Subject: RE: Ross Cottage Planning DoC -- WA/41/21/DOC

On the basis of the comments below I recommend that Condition 3 imposed under application ref WA/78/20/HH is discharged. Please ensure all surface water drainage is constructed in accordance with the following documents:

- Surface Water Drainage Dwg No MGS—WA/78/20-rev03
- Constructional Details Dwg No MGS—WA/78/20-rev04

Drawing Number MGS -- WA/78/20-rev03

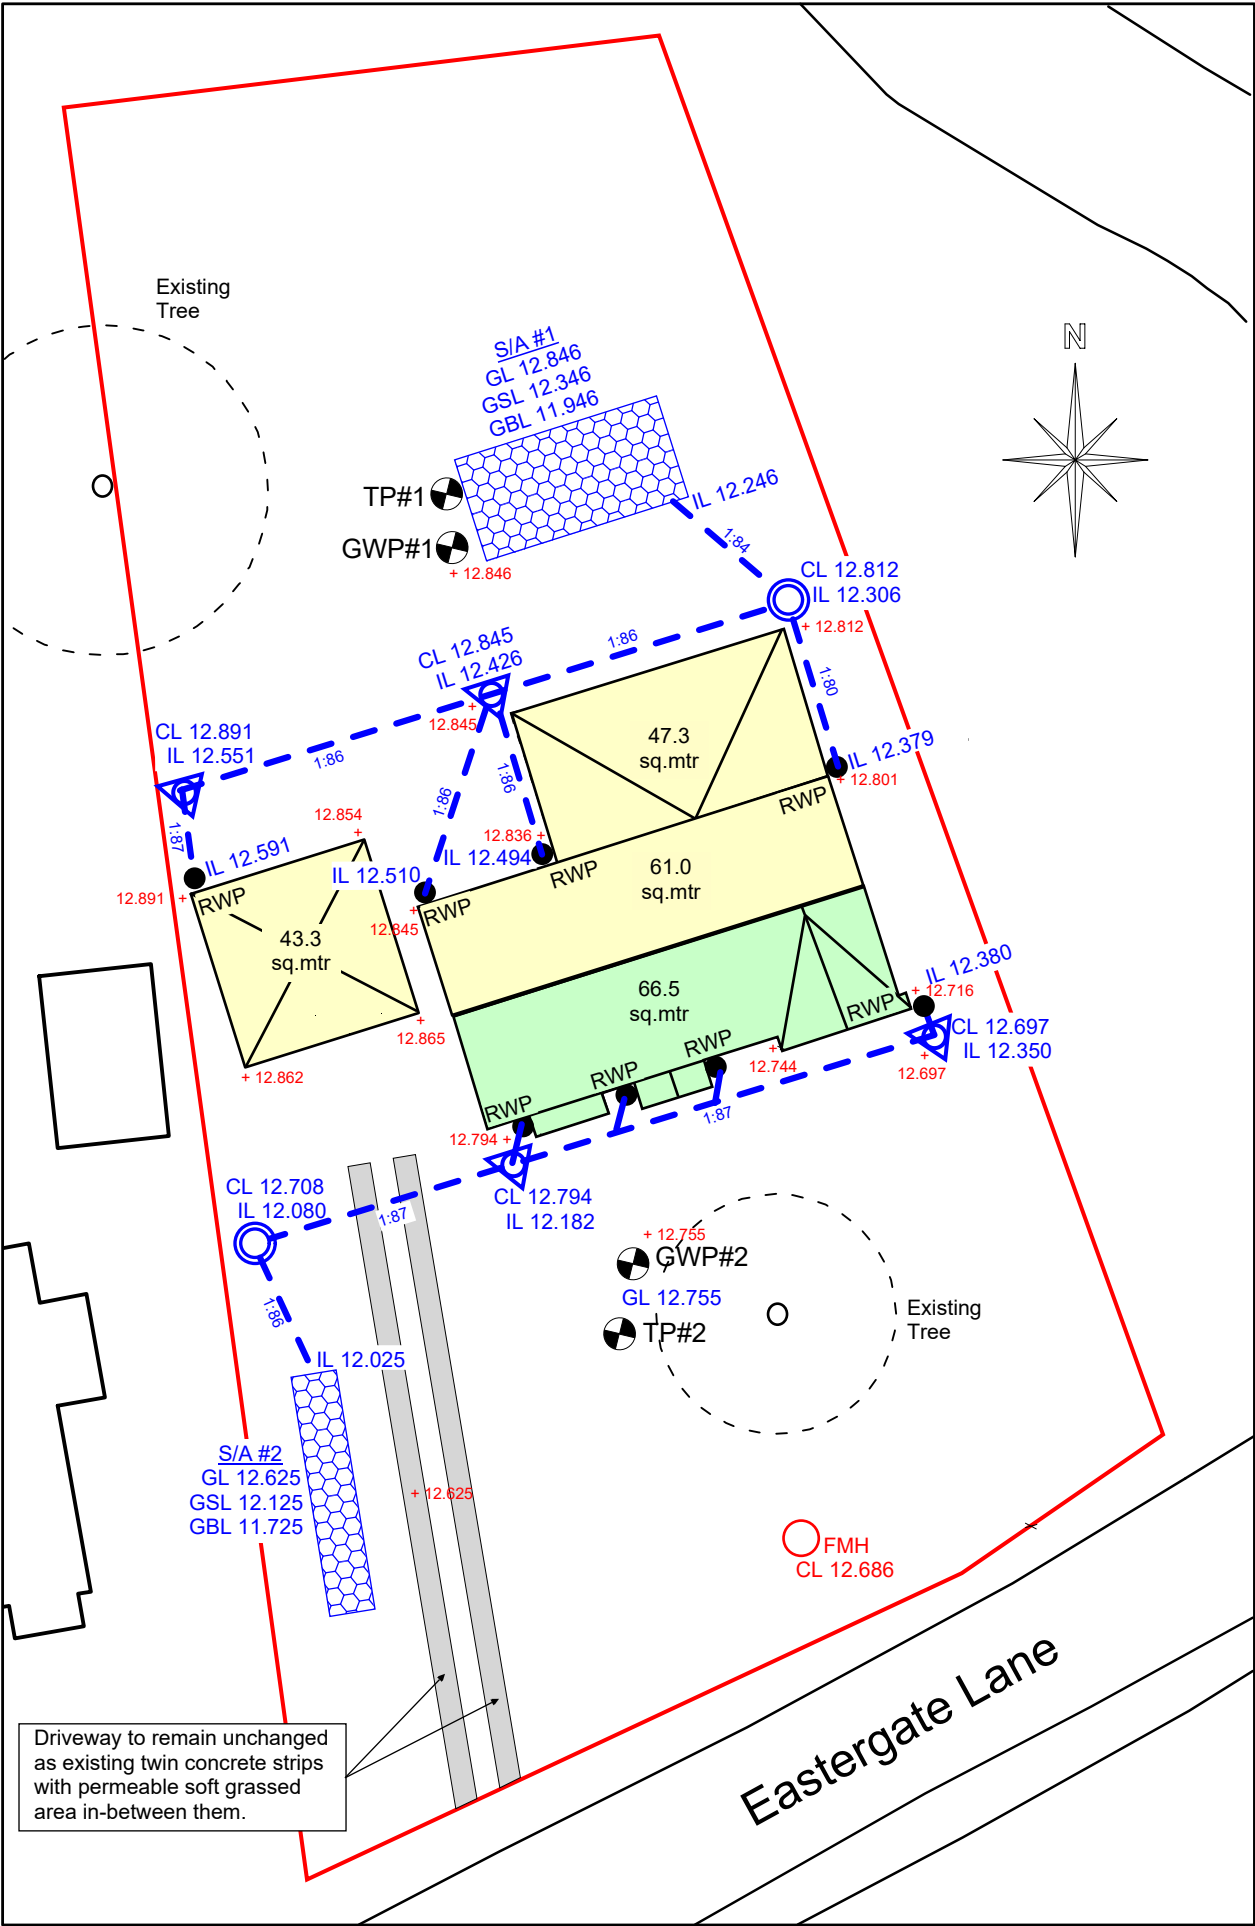
I can state that the distance from the soakaway in the front garden to it's adjacent boundary is 1.9 metres.

This is not quite achieving 'Best Practice' of a distance of 2.5 metres, but is considered satisfactory since it is believed that there is no infiltration structure close by in the front garden of the adjacent property.

The location of the soakaway in the strip following the existing driveway was a compromise, since the obvious place was to locate it in the front garden area.

Any future change to the garden layout could potentially compromise a soakaway constructed to meet this current Planning Application, so it was decided to locate it well away from any future possible changes.
